**2 AUSTRALIA AVE, SYDNEY OLYMPIC
PARK**

ACCESS REVIEW

FINAL

9th December 2010

BASEMENT 1
1:600 @ A1 1:1200 @ A3

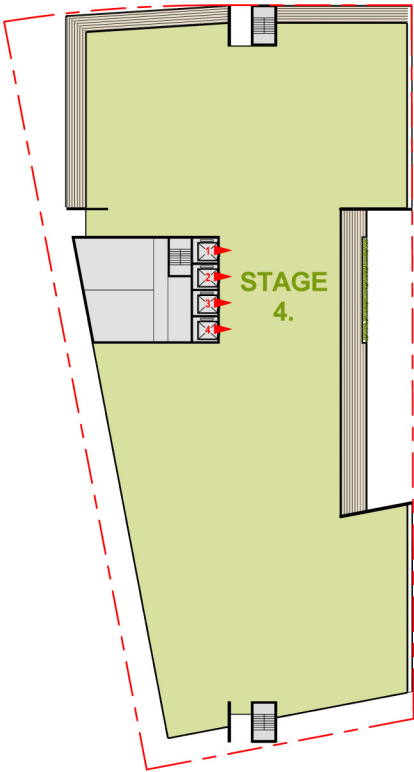
There are two levels of basement car parking provided. Currently there is no accessible car parking bays present on the plans provided.

There are approximately 240 proposed underground car parking bays. Modification is required to provide 3% of the car parking provided are required to be accessible parking spaces, compliant with Sydney Olympic Park Access Guidelines.

- (i) Ensure there is at least 8 accessible car parking bays allocated in the basement car parking, in compliance with the Sydney Olympic Park Access Guidelines.
- (ii) Ensure the accessible car bays should have 2.4m width with 2.4m width shared zone to comply with AS2890.6.
- (iii) The accessible car parking spaces in basement levels to have a clearance height 2500mm with 2200mm high when approaching the space in compliance with AS2890.6.
- (iv) The accessible car bays should be located within close proximity to building entrances/lifts.

LEVEL 1
1:600 @ A1 1:1200 @ A3

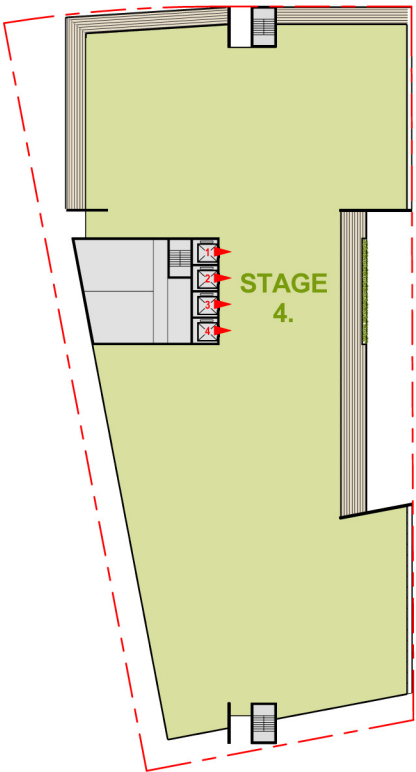
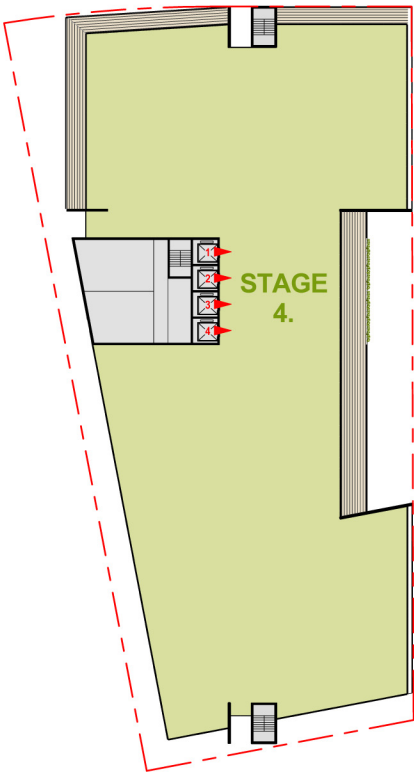
The corridors leading to the accessible toilets on levels 1 - 7 appear to be 1300mm. The end of the corridor does not allow a person in a wheelchair to turn 180 degrees. Modification is required to ensure ends of corridors will allow a person in a wheelchair to turn 180 degrees.

Male and female toilets are provided from level 1 to 7. Currently drawings do not show ambulant cubicles within the banks of toilets. Modification is required to provide 1 ambulant cubicle in each male and female toilet to comply with the DDA Premises Standard and Sydney Olympic Park Access Guidelines.

- (i) Ensure that the ends of the corridor leading to the accessible toilets is in line with the DDA Premises Standards. A minimum 2070mm (L) x 1540mm (w) is required along the corridor ends (outside the accessible toilet door) to allow wheelchair users to turn 180 degrees.
- (ii) Ensure an accessible unisex toilet with dimensions to accommodate 2300mm x 1900mm circulation space around the toilet pan with the basin only encroaching by 100mm, compliant with Sydney Olympic Park Access Guidelines clause 3.3.
- (iii) Ensure there is a balance of left and right hand transfer accessible pans in accordance DDA Premises Standard.
- (iv) Ensure the accessible toilet door has a 850mm clear width (920mm door leaf) to comply with Sydney Olympic Park Access Guidelines..

- (i) Ensure there is 1 ambulant cubicle in each male and female toilet to comply with the DDA Premises Standard and Sydney Olympic Park Access Guidelines.
